CITY OF ALBUQUERQUE

July 8, 2011

**Re: Ingersoll Rand Trane
Grading and Drainage Plan
Engineer's Stamp dated 6-28-11 (B18/D005)**

SHEET NUMBER
CG-101

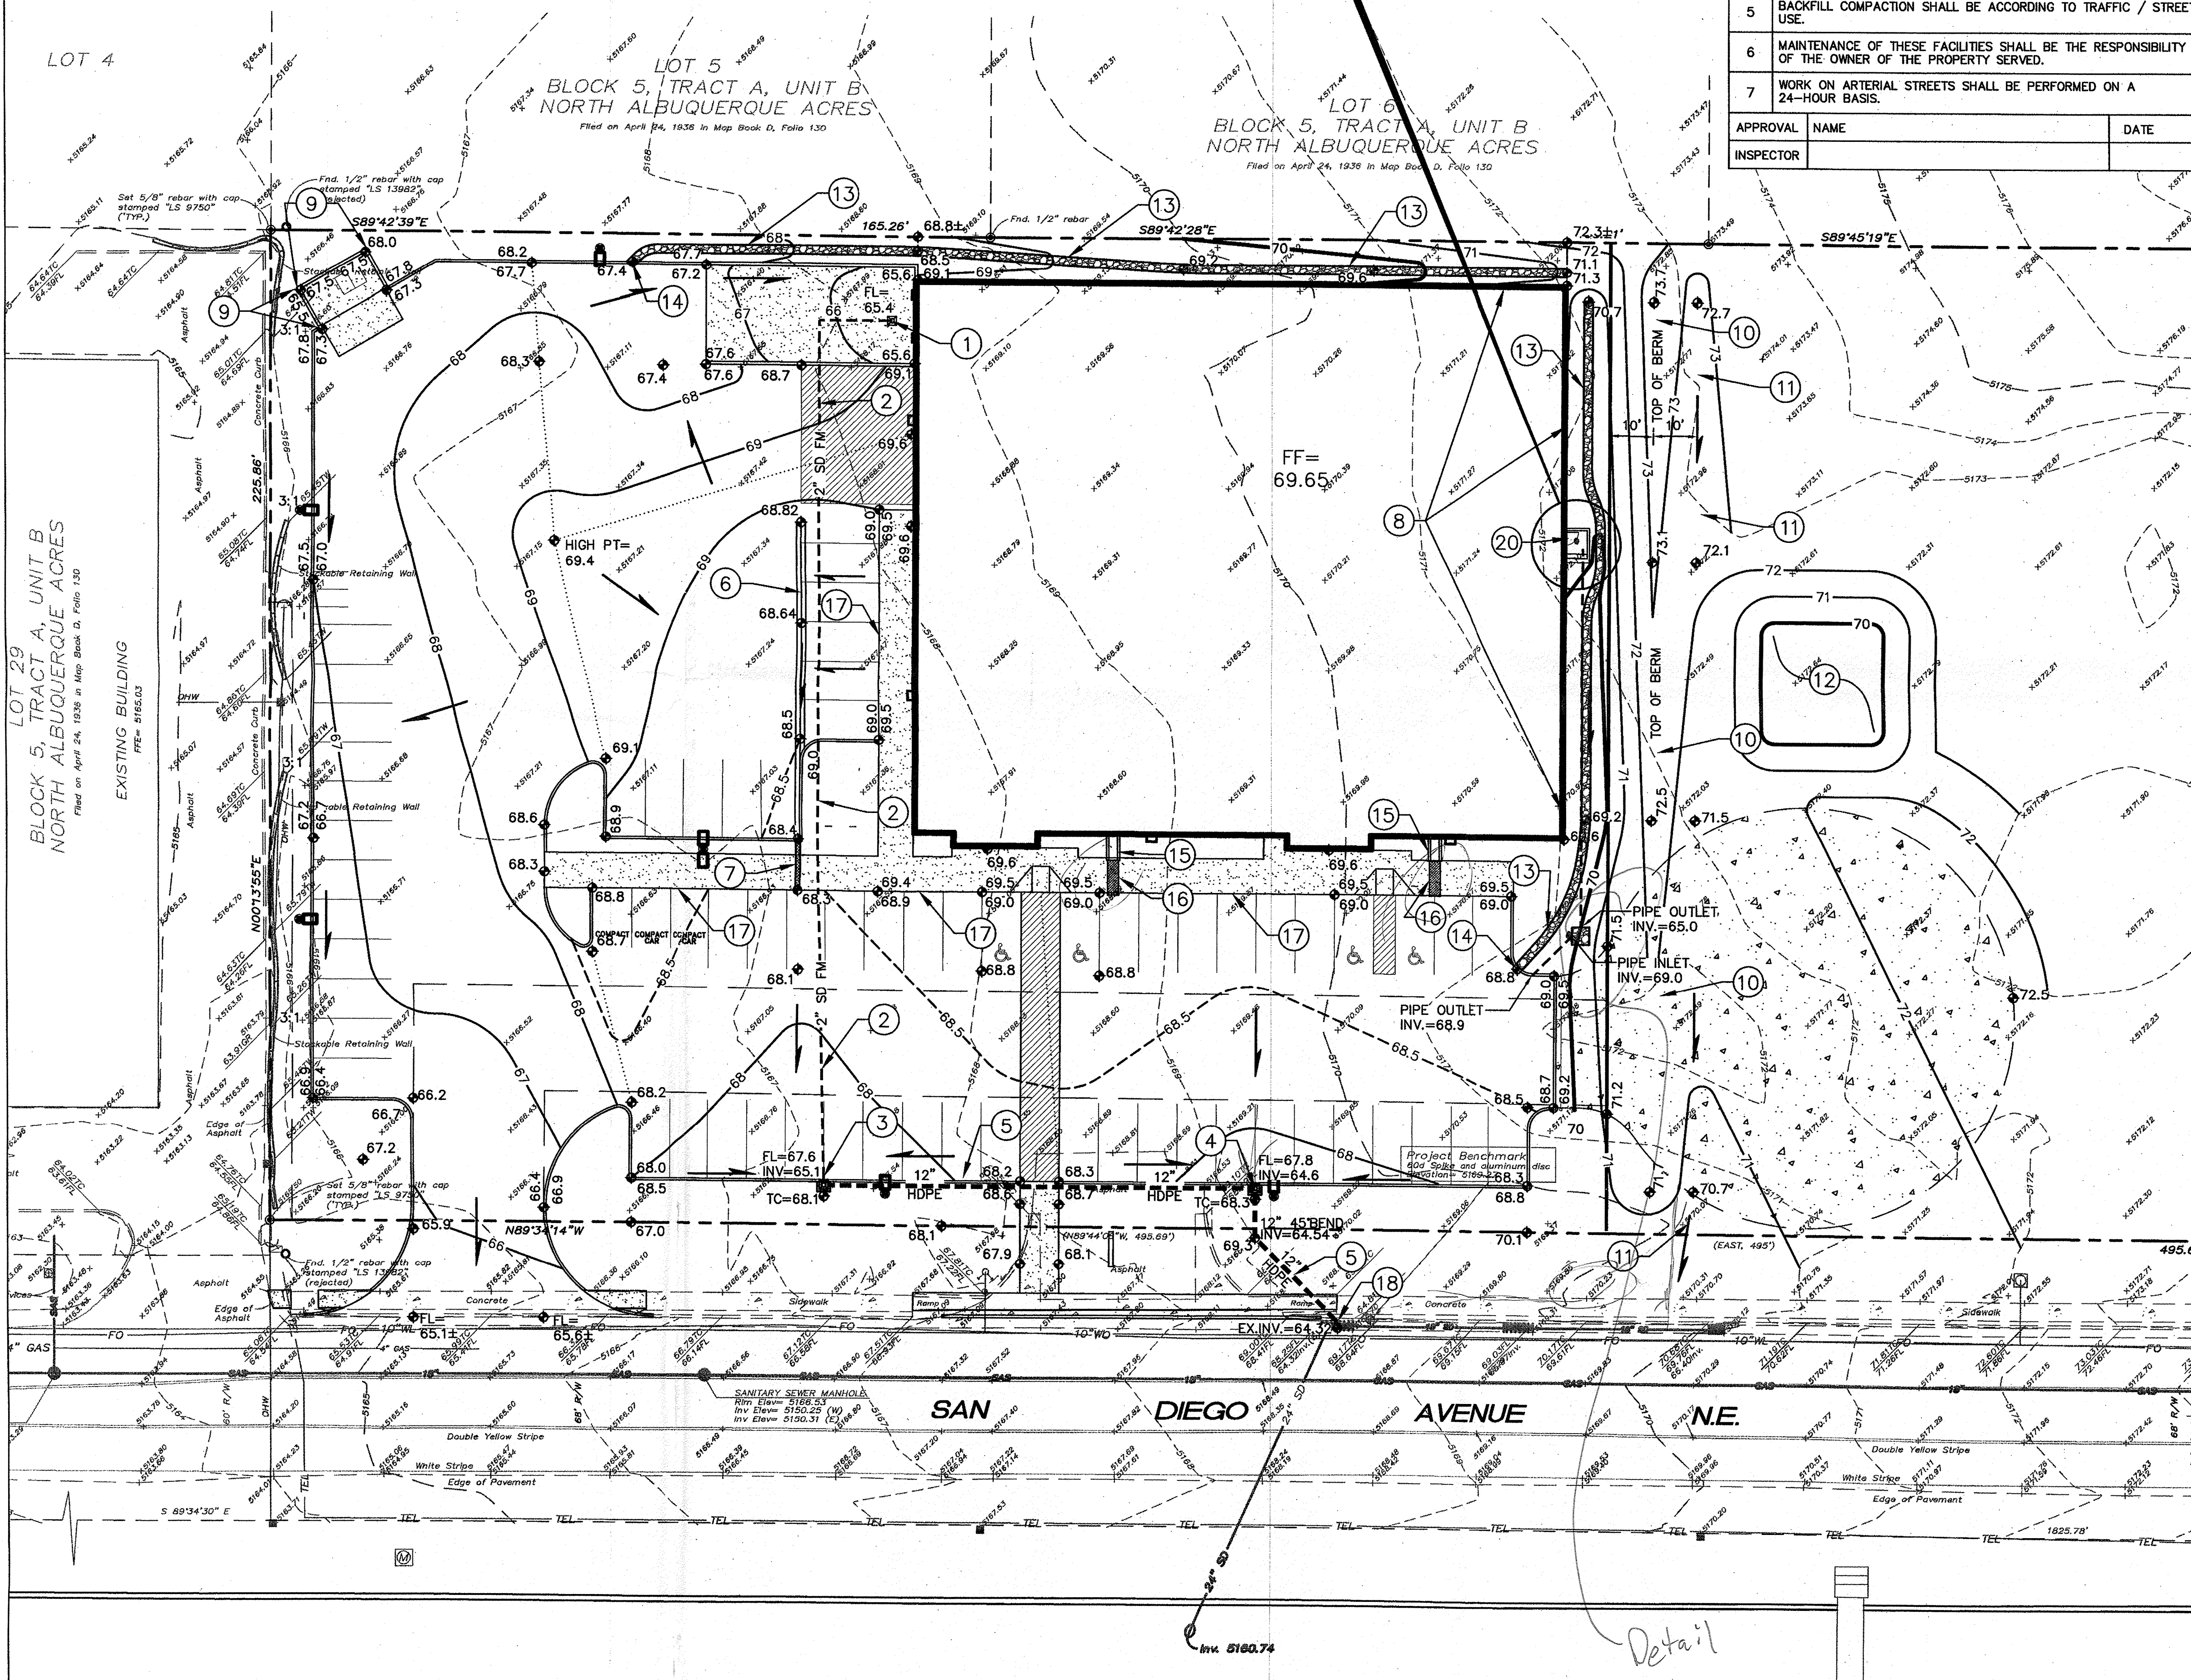
Hydrology is requesting that all proposed landscape areas are depressed to retain/infiltrate the moisture that falls on them.
